Please upload the below to the above application. WSCC further comments.

'The change of use of land for the storage of building materials, equipment & plant & for the parking for fixed body vehicles together with part boundary screen fence with a secure gated access point to the site.'

PROPOSED SITE PLAN - 1:200

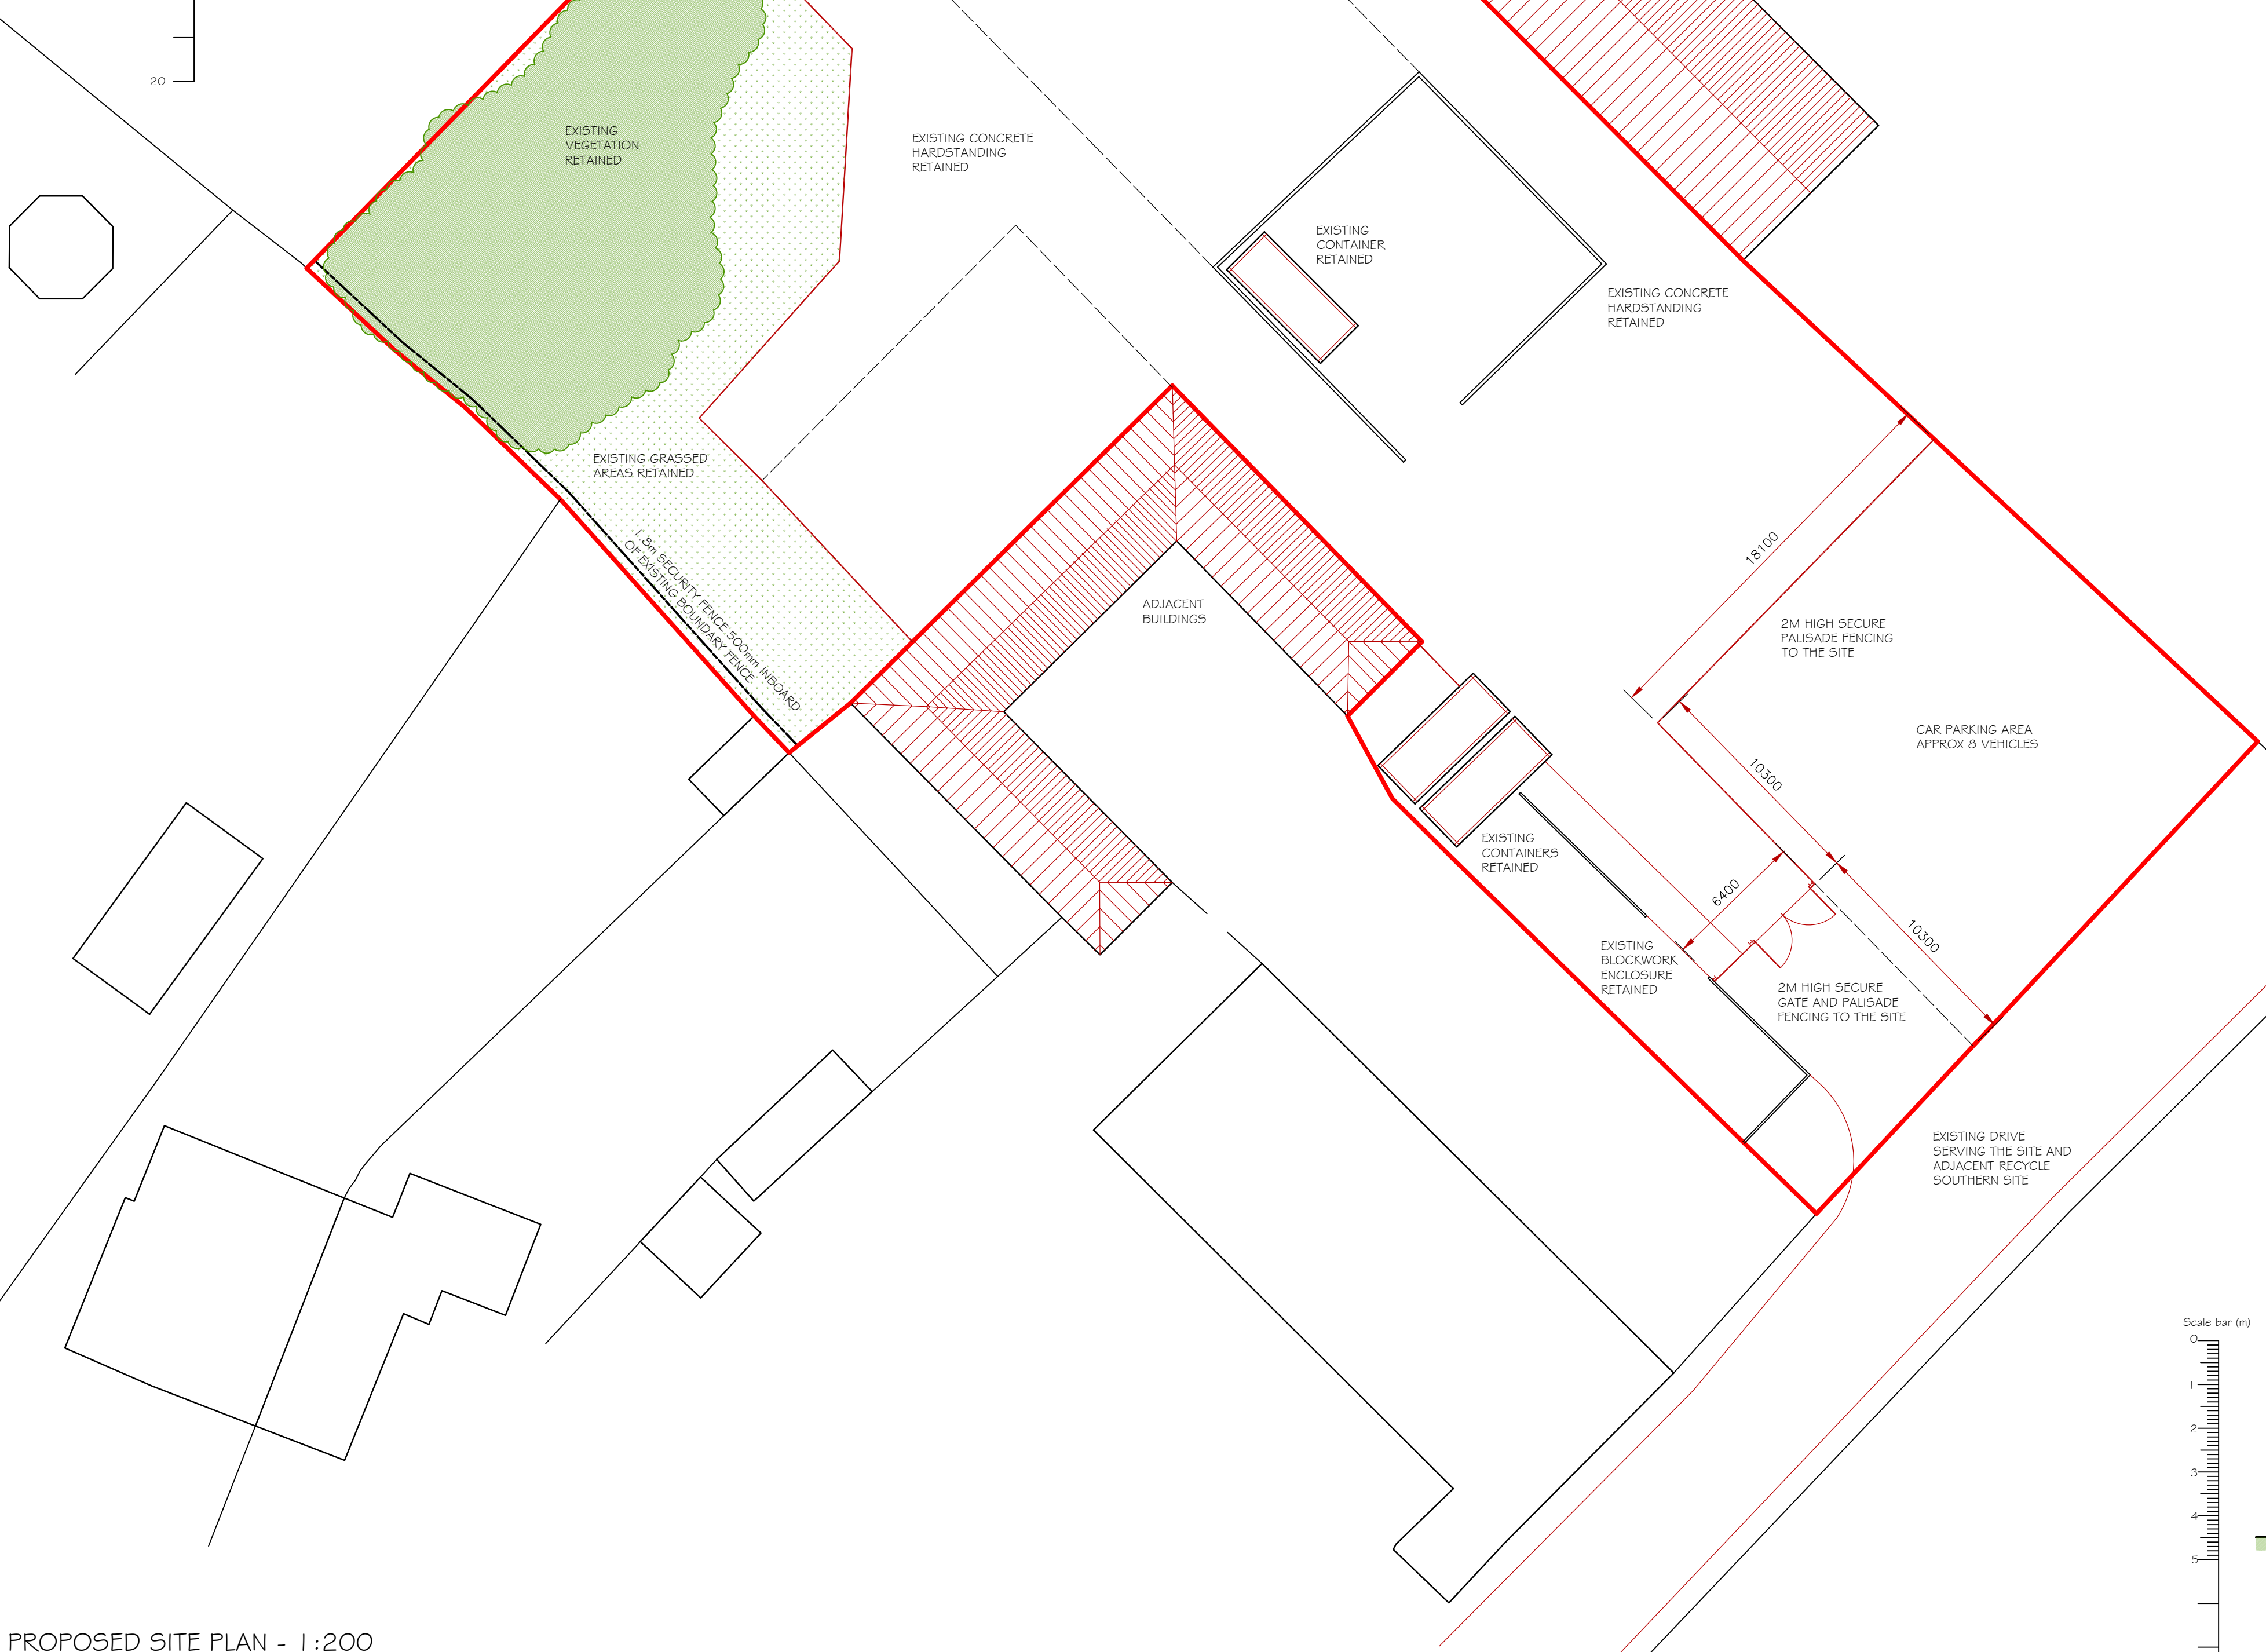
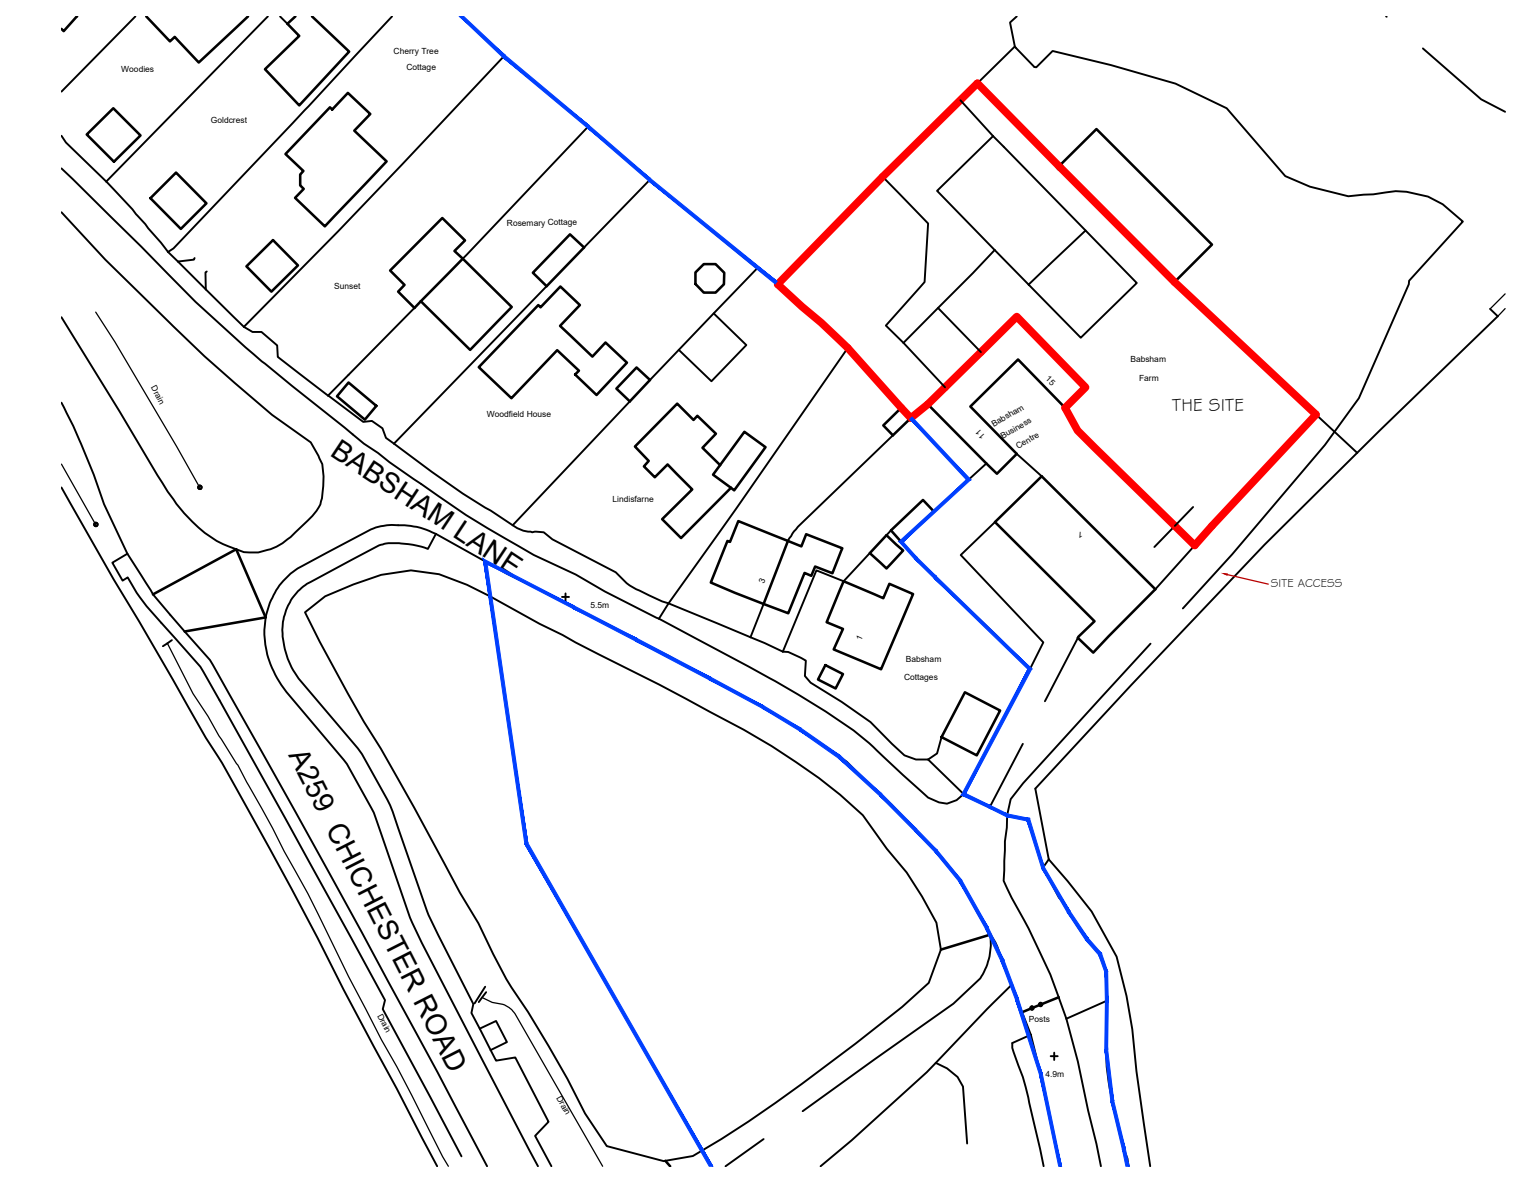
I have just sent my response to the planning inbox, I have requested more information, as although they has demonstrated the gate, they have revised the plan to show 'parking for up to 8 vehicles', no longer designated HGV parking for 2 HGVs as the application suggests – are they now proposing parking for 8 HGVs? They also have not shown how HGV vehicles will turn on site – particularly, if there are 8 proposed HGVs, there will be limited space. If they are now proposing the parking area for cars only, where are they now proposing HGV parking? And could any revised HGV parking area provide suitable turning provision?

I have discussed the fence with Dan and I have been invited by the local resident to see the site from her point of view and I have attached photo. The proposed fence is much better, however not immediately behind of the rear of residential gardens.

And what about the space in the between? How much and how it will be kept?

'The applicant has referenced that gates will be erected on the access track to improve security. No details of the proposed gates have been provided. The applicant is requested to demonstrate the location of the proposed gates on the plan, including details of how and when these will be in operation, and any necessary measures that will be taken to avoid vehicle conflict and queuing on the public highway.

The applicant has not demonstrated how articulated vehicles are currently turning on site. The applicant is requested to provide details of this, and if necessary, should demonstrate with swept path analysis that the proposed positioning of the gates will not impact upon the ability for articulated vehicles to turn on site.

What we request is the position of the proposed fence to be changed (as suggested).

I have just provided a revised response to you. Hopefully this helps. As they are no longer proposing HGV parking, I don't think swept path tracking is necessary any longer.

We intend on indicating a palisade type fence across part of the frontage of the site with a defined parking area outside of this fence line. The parking area will be for fixed body vehicles (cars, vans and on articulated lorries etc.) belonging to the tenants of the site only and will be subject to the operating hours of the site only - to be agreed under condition.

Within the palisade fence there will be a secure gated access point to the site.

With regards to the proposed fence at the rear of the site our client is proposing removing the fence completely from the application and will rely on the existing rear garden fences of the adjacent properties and the part masonry walls already on site. The area of existing planting and self seeded trees and shrubs will be retained.
